**Our Case Number:** ABP-319448-24

An  
Bord  
Pleanála

**Date:** 07 MAY 2025

**Re:** Proposed Development of an 8 no turbine wind farm development and associated works on land within the townlands of Clonmellon, Kilrush Upper, Kilrush Lower, Newtown, Ballinlig, Carnybrogan, Cavestown and Rosmead, County Westmeath and Galboystown, Co. Meath. ([www.knockanarraghwindfarmsid.ie](http://www.knockanarraghwindfarmsid.ie))

Drawing Title
Turbine Elevation

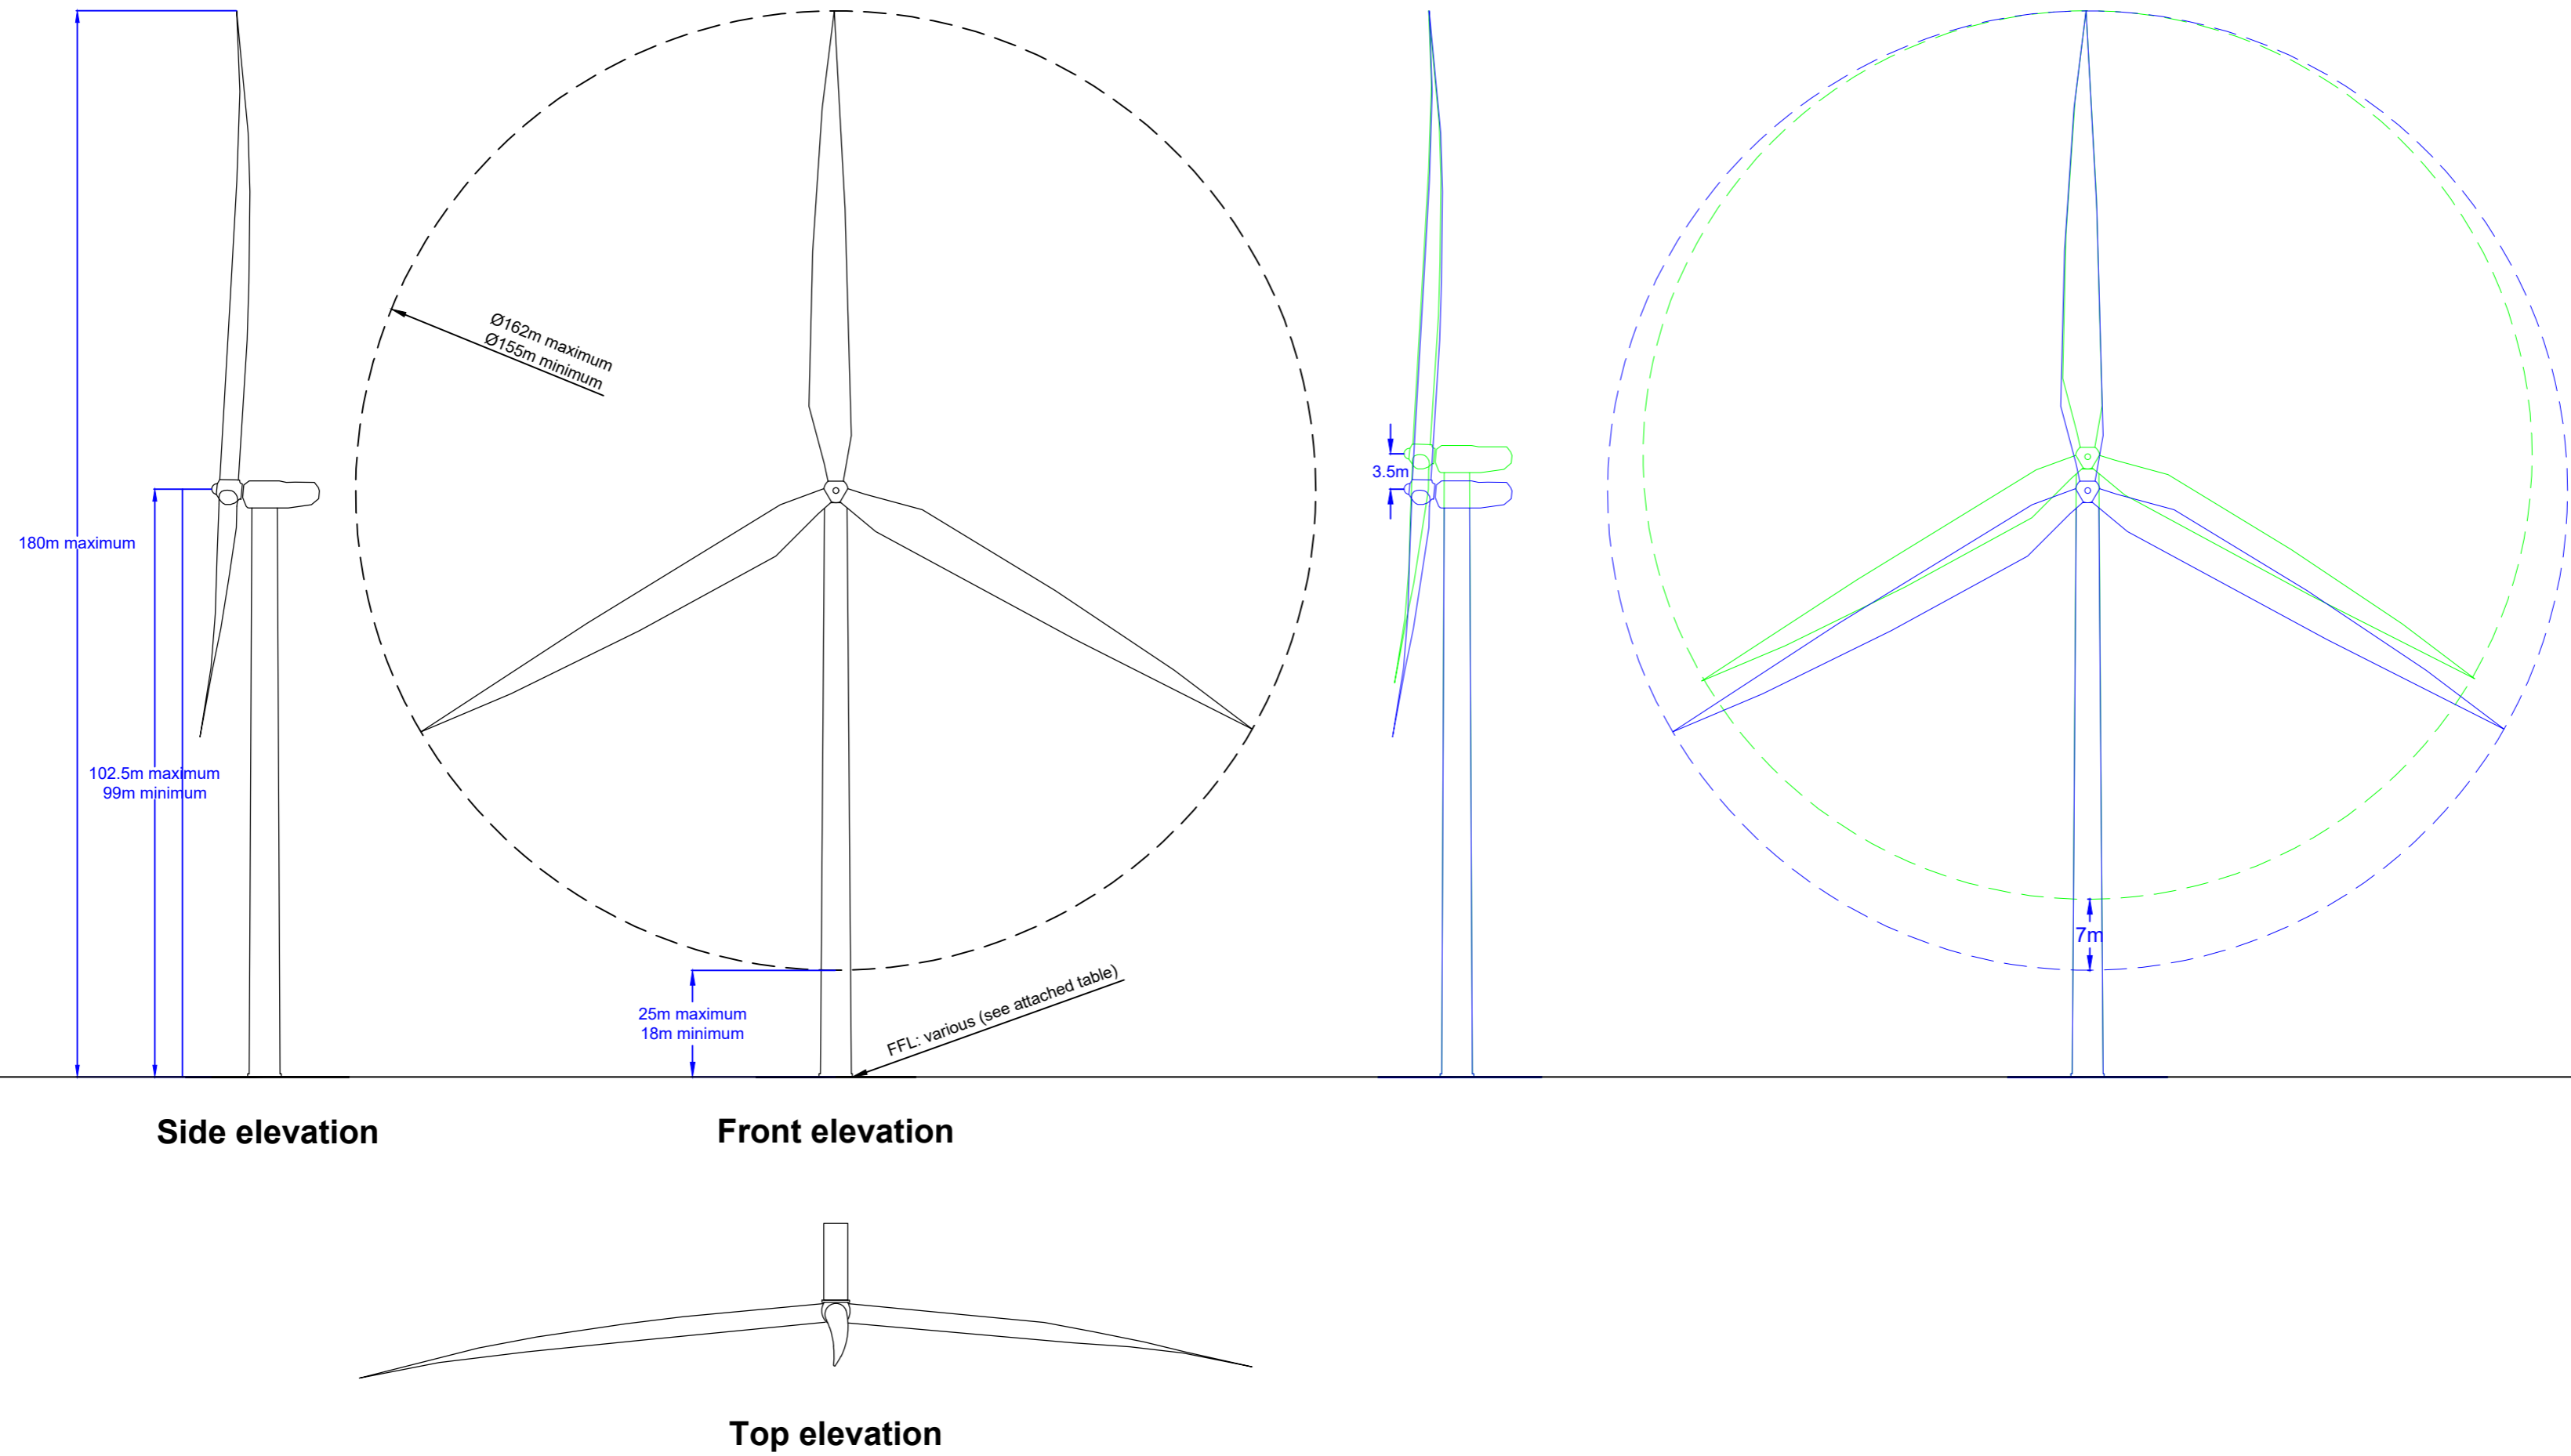
Please note that an error occurred in Condition Number 4 in the Condition section of the Board's Order in that it is stated: "The following design requirements shall be adhered to:

(a) The wind turbines shall be designed to a hub height of 99 meters, a rotor blade diameter of 180 meters and an overall height of 180 meters, in accordance with the turbine option assessed in the Environmental Impact Assessment Report and Natura Impact Statement, together with the application documentation.

Should more properly have read as follows: "The following design requirements shall be adhered to:

(a) The wind turbines shall be designed to a hub height of 99 meters, a rotor blade **diameter of 162 meters and an overall height of 180 meters**, in accordance with the turbine option assessed in the Environmental Impact Assessment Report and Natura Impact Statement, together with the application documentation.
